Sue Howell
Parks and Greenspace
37943

Mrs C Rodway
Planning Services

**RE APPLICATION : BOGNOR REGIS CAMPUS, UPPER BOGNOR ROAD, BOGNOR
REGIS, PO21 1HR BR/227/10**

Appendix 6:
Tree Constraints Plan

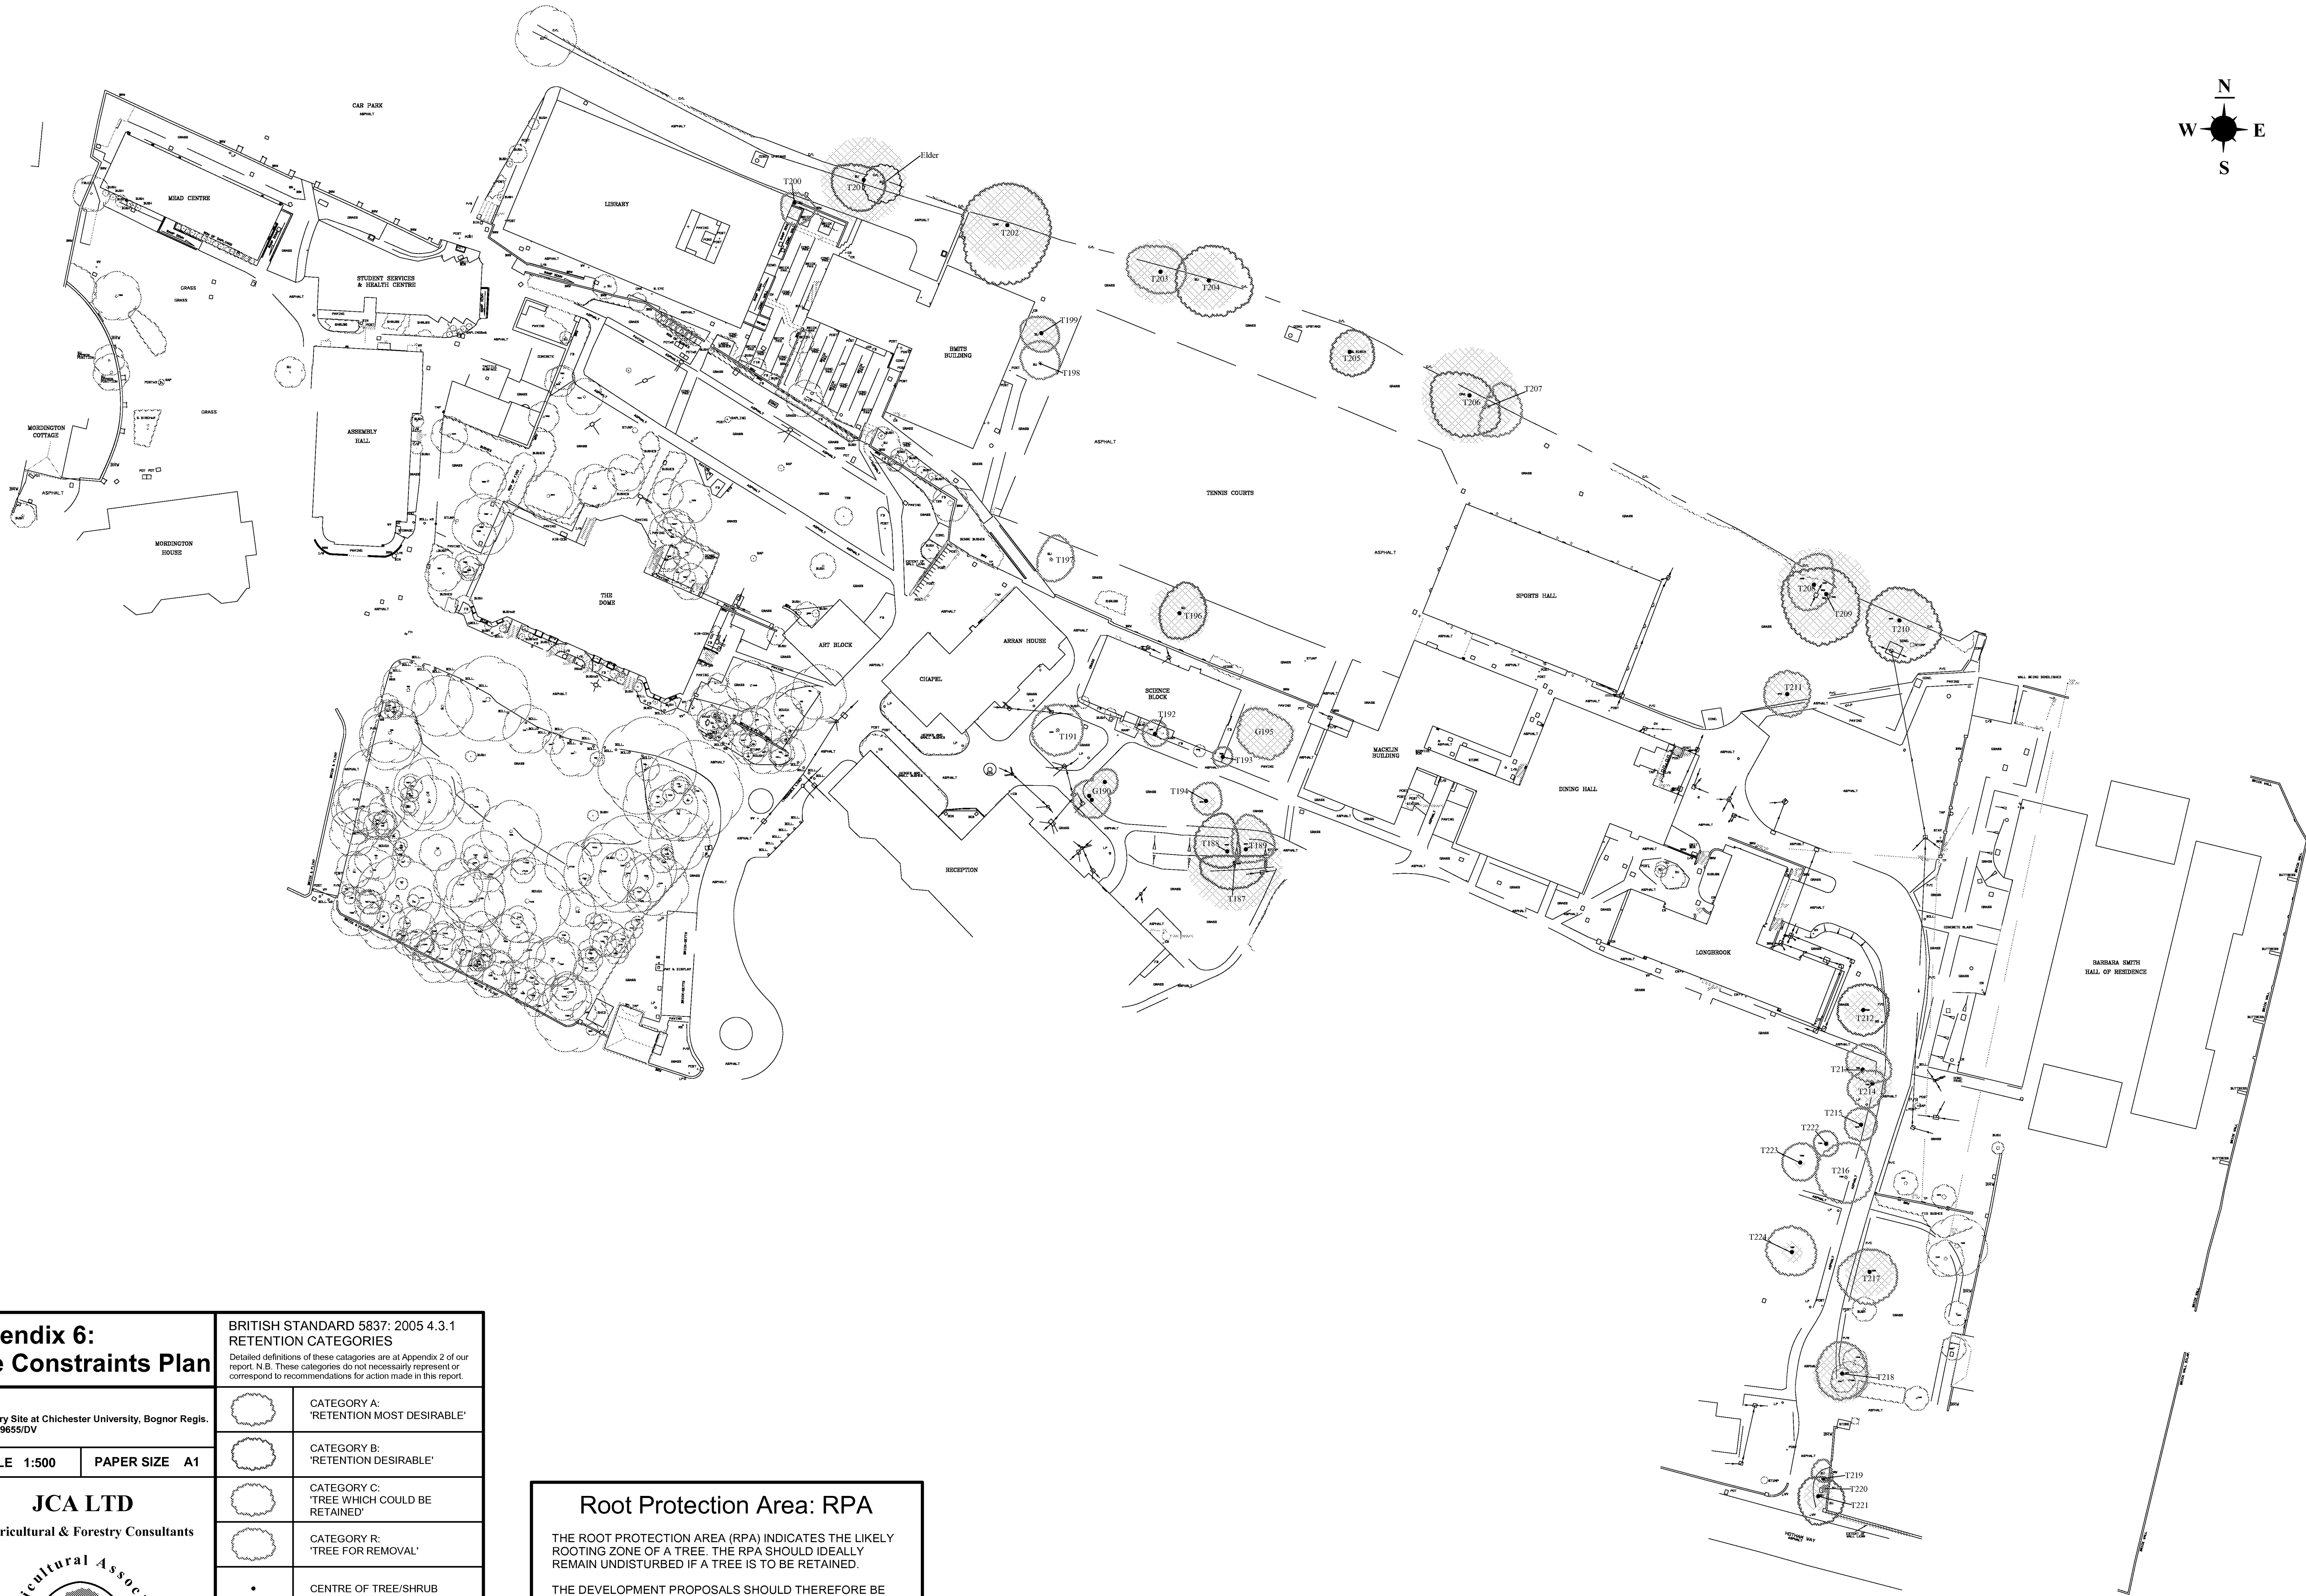
The trees highlighted for removal are T214, T216, T219, T220 and T221 we have no objection to the removal of these trees as they display largely little or no amenity value to the present surroundings, being in some cases dead or diseased and desired of removal. – We would however recommend as a condition of the approval that the removed trees to the frontage corner are compensated for; with the re-planting of new trees and shrubs in the locale. These would form part of a landscape plan for the whole area with particular attention to be given to the space to the West of the entrance where compensatory planting could clearly be facilitated.

The trees highlighted for pruning T213, T217 and T218 would lead us to advise only that they would require pruning in line with good horticultural practice.

T212 is the tree which we would highlight as being significantly impacted by the proposals. This tree is worthy of retention and the proposed plans, could compromise the wellbeing of this tree. The plans show that the proposed construction of the extended roadway will extend well into the trees root zone. We would advise only that every care should be taken to ensure it's protection (Trees in relation to construction) if it is to survive and flourish.

As a point of note it should be considered that if the proposed passing point could be sited further along this roadway, then T212 would be little or non affected by the proposals.
